Permit Number: 040073

has permission to New 1870 sq. Ft. Single Family home with detached garage.

AT 164 Marlborough Rd Lot #1 406 F029001

All Purpose Building Permit Application

CROSS SECTION A-A  
SCALE: 1/4" = 1'-0"

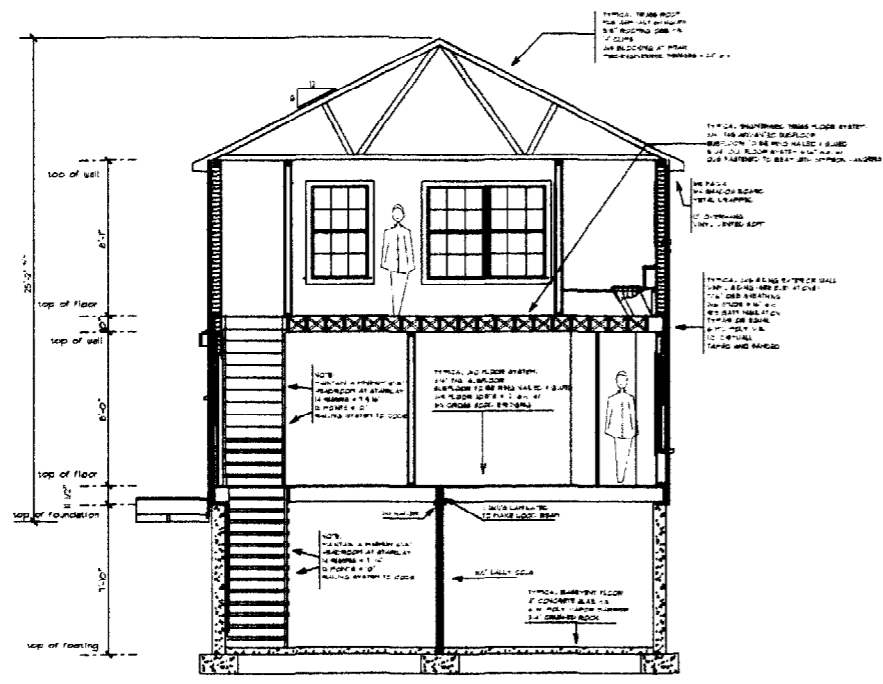
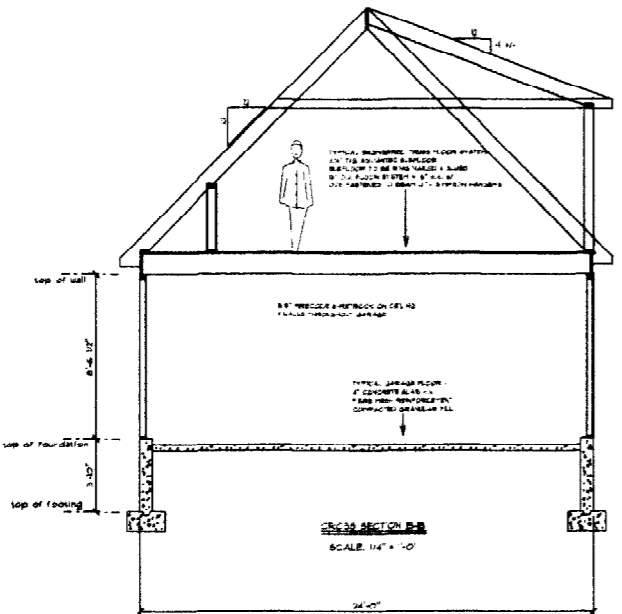
Attic or additional Floor Joist Species Dimensions and Spacing (Table 802.4.2 or 503.3.1(1) & Table 503.3.2(1))	2x6 collarties - OK	GARAGE ONLY HOUSE IS TRUSSED
Roof Rafter; Pitch, Span, Spacing & Dimension (Table 802.3.2(7))	OK	
Sheathing; Floor, Wall and roof (Table 503.2.1(1))	OK	
Fastener Schedule (Table 602.3(1) & (2))	NOT SHOWN	12D. Framing Glue & Keny Sheath 1500 & 2D Sheathing 3x4x104
Private Garage Section 309 and Section 407 1999 BOCA) Living Space? (Above or beside) YES Fire separation OK noted 5/8"		<u>All 5/8 Fire code</u> <u>Taped Studed</u>
Fire rating of doors to living space Door Sill elevation (407.5 BOCA)	NOT SHOWN	<u>2nd</u> garage to house
Egress Windows (Section 310) <div style="border: 1px solid black; padding: 2px; width: fit-content;"> CITY OF PORTLAND, MAINE APPROVED CONSTRUCTION PLANS FEB 25 2004 SUPERSEDES ALL PREVIOUS PLANS </div>	NOT SHOWN	ON PLAN
Roof Covering (Chapter 9)	OK

12	Header Schedule	not shown	
13	Type of Heating System	not shown	
	Stairs Number of Stairways 2 Interior 2 Exterior 1 step Treads and Risers - 10" Tread (Section 314) 7/4" Rise + 7 9/16" Rise } OK Width - OK Headroom — Will <u>NOT</u> meet 6'-8"	(F) Winder dimensions <u>NOT</u> shown	
15	Guardrails and Handrails (Section 315)	not shown	
16	Smoke Detectors Location and type/Interconnected	not shown	
	Plan Reviewer Signature

Header Schedule	Not shown	3-2X10 ALL EXCEPT GARAGE DOOR
Type of Heating System	Not shown	HWSB
Stairs	Direct vent - OK	
Number of Stairways	2	
Interior	2	(A) <u>Winder dimensions</u>
Exterior	1 step	<u>NOT</u> shock
Treads and Risers (Section 314)	10" Tread - 7/4 Rise + 7/16" Rise OK	HWSB
Width - OK		
Headroom	Will <u>NOT</u> meet 6'8"	CORRECTED with new PLAN
Guardrails and Handrails (Section 315)	Not shown - OK	All stairways
Smoke Detectors Location and type/Interconnected	Not shown	All Bedrooms + 1 Per Floor, Hst + detector in Garage
Plan Reviewer Signature

**Plan View**  
1/4" = 1'-0"

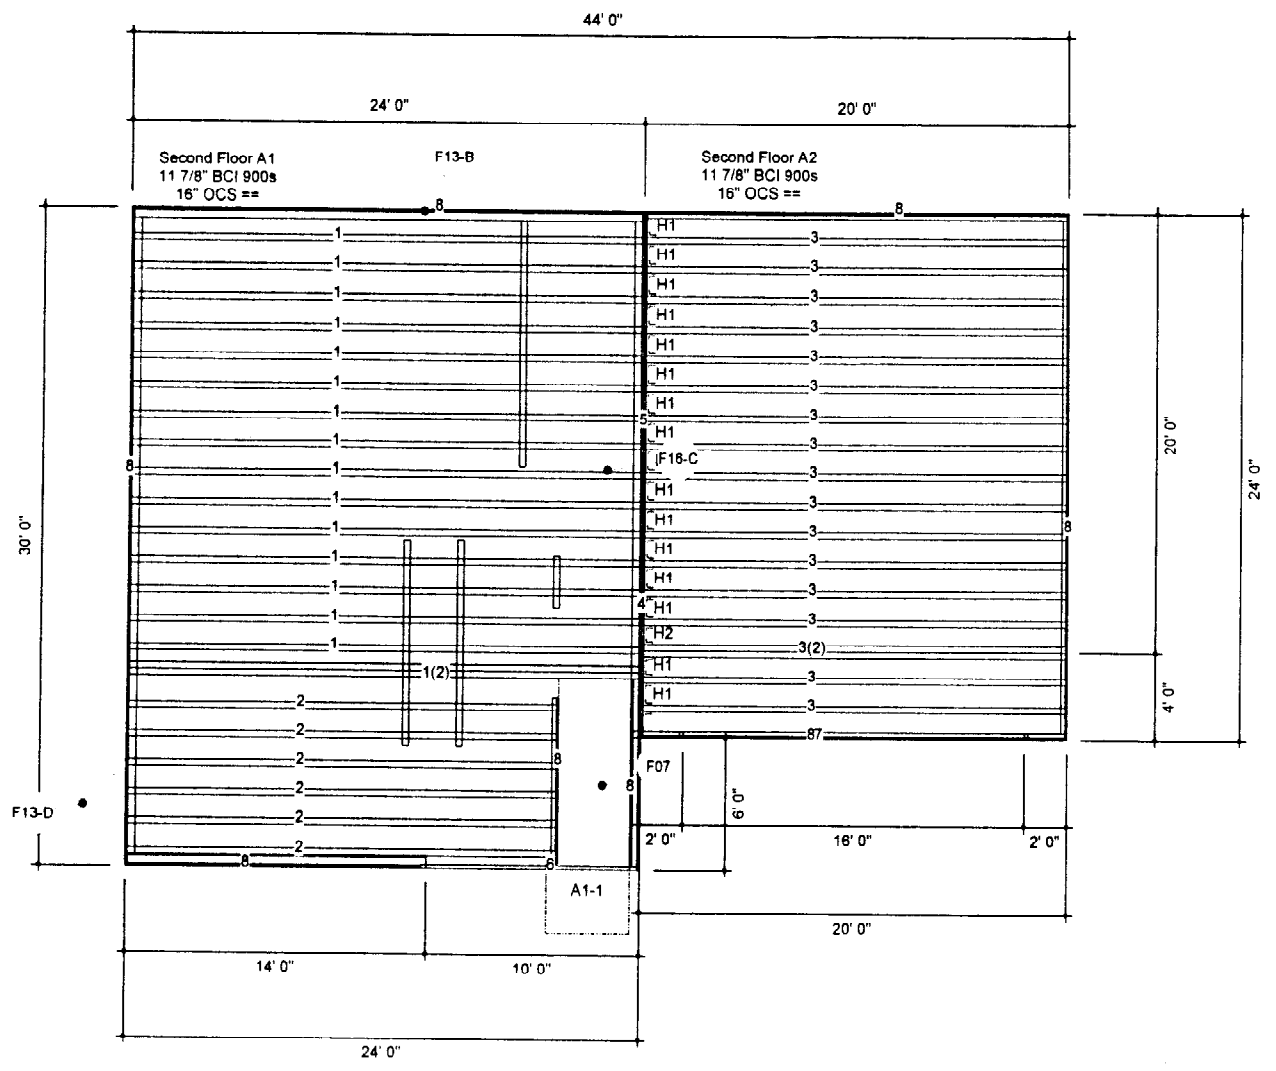
⑥ ~~Stair framing opening Not adequately supported.~~

⑥ Stair framing opening Not adequately supported.

Corrected on Plan Support wall added in Basement.

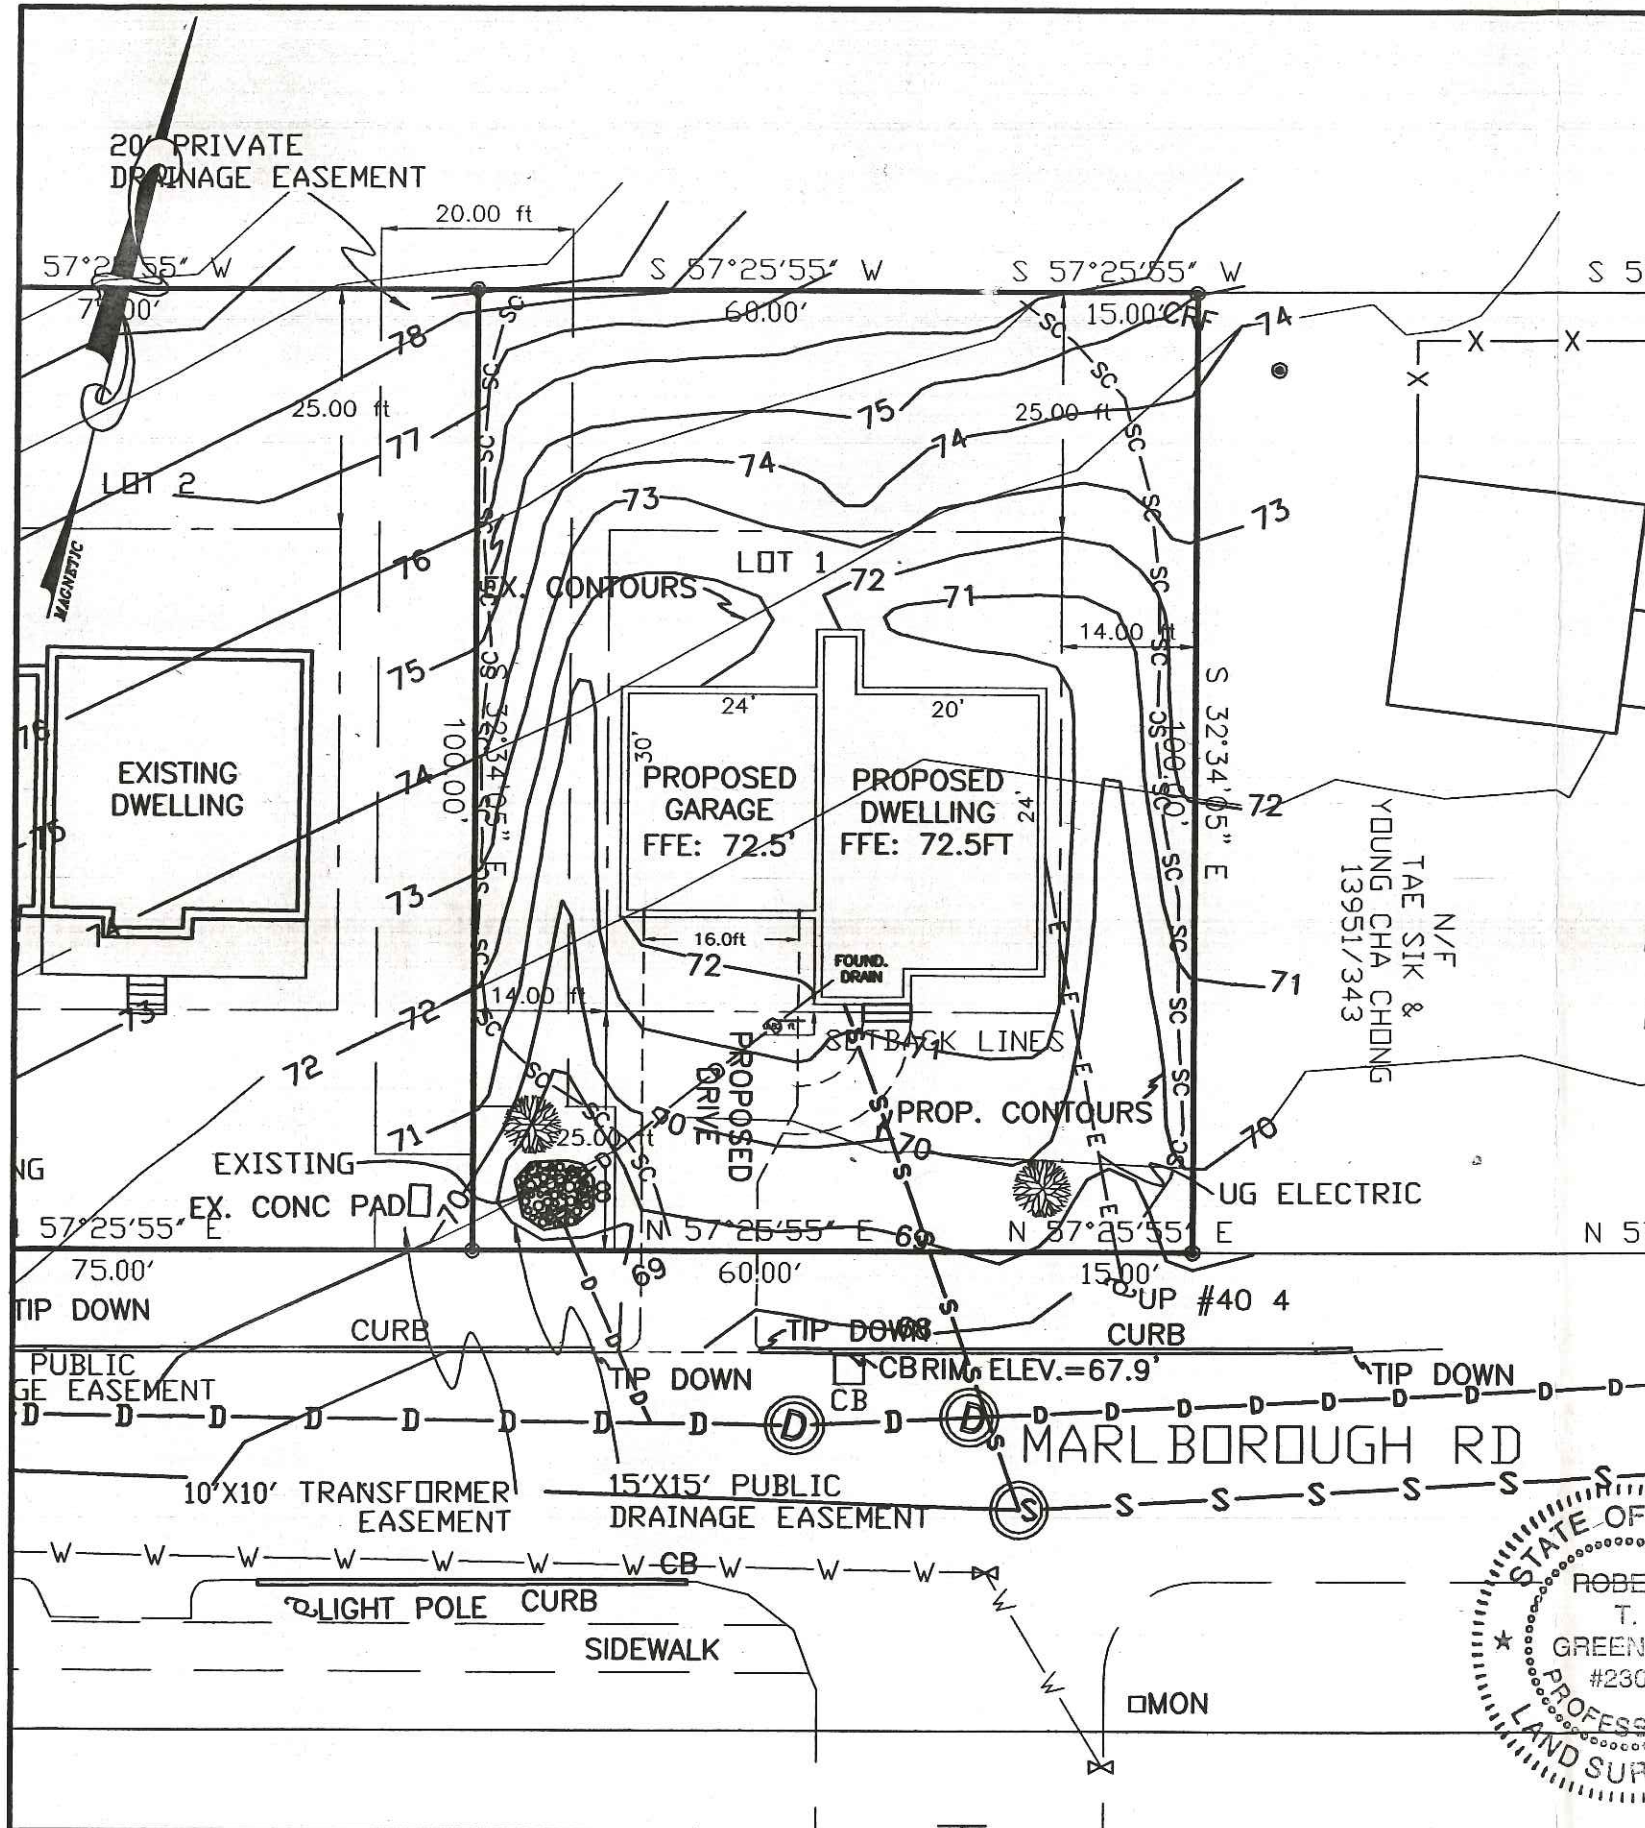
Note: 2/12/04 just received the approved site plan - the plot plan does not match the structural plans - left number with Coley Walsh. **Ok to Issue:**

2/17/04 Coley Walsh called me back and did know that we needed revised plans - I again explained the differences in plans.

2/19/04 Coley was inand revised his structural plans to eliminate the rear deck.

NO REAR Deck
(removed from structural plans)
